From: Sue Howell
Sent: 21 May 2019 16:24
To: Planning.Responses
Cc: Stuart Corbey
Subject: RE: Planning Consultation on: FP/30/19/PL

Comment from Greenspace

NOTIFICATION FROM ARUN DISTRICT COUNCIL
Town & Country Planning Act 1990 (as amended)
Town and Country Planning (Development Management Procedure) (England) Order 2015
Planning Permission
APPLICATION NO: **FP/30/19/PL**

Registered: 12th February
2019
Site Address: 10 South Road Felpham PO22 8EF
Grid Reference: 494939 100205
Description of Works: Demolition of chalet & erection of 1 No. 4 bedroom chalet
(resubmission following FP/234/17/PL)

Site plan
10 South Road
Felpham
Scale 1:500

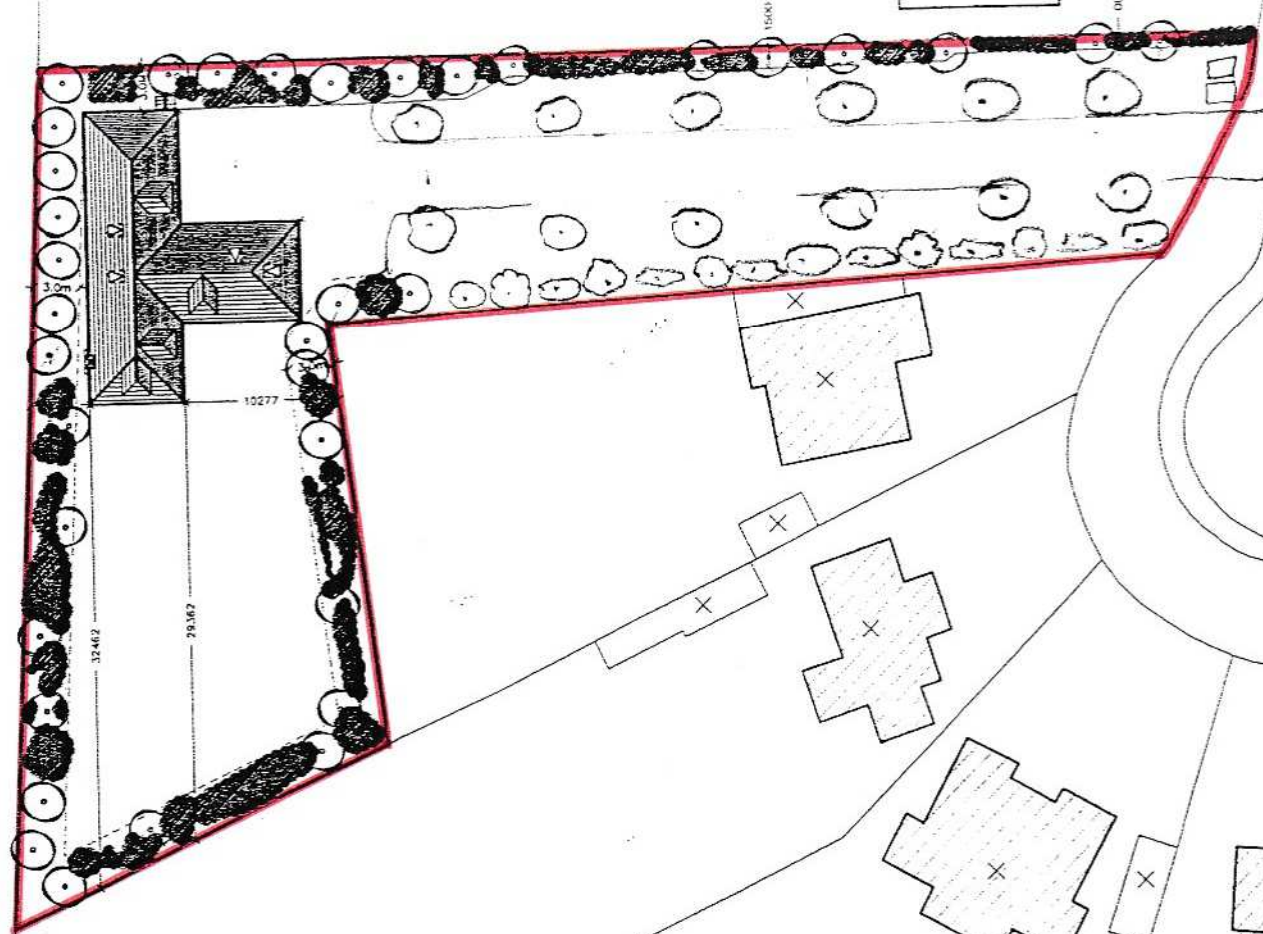
There would be a requirement for the submission of a detailed landscape plan to detail the trees and shrubs to be retained with this development. The planting plan would need to provide detail of a scheme which would complement the existing, be beneficial habitat forming to promote and enhance the biodiversity of the site and contain a mix of deciduous and evergreen, native and ornamentals.

Mitigation tree planting may be required for screening purposes and in compensation for any tree removal. Any tree works within the site would need to be in consultation with Arun District Council. Tree protection measures to be in place before any demolition or construction works to protect retained trees within and bordering the proposals.
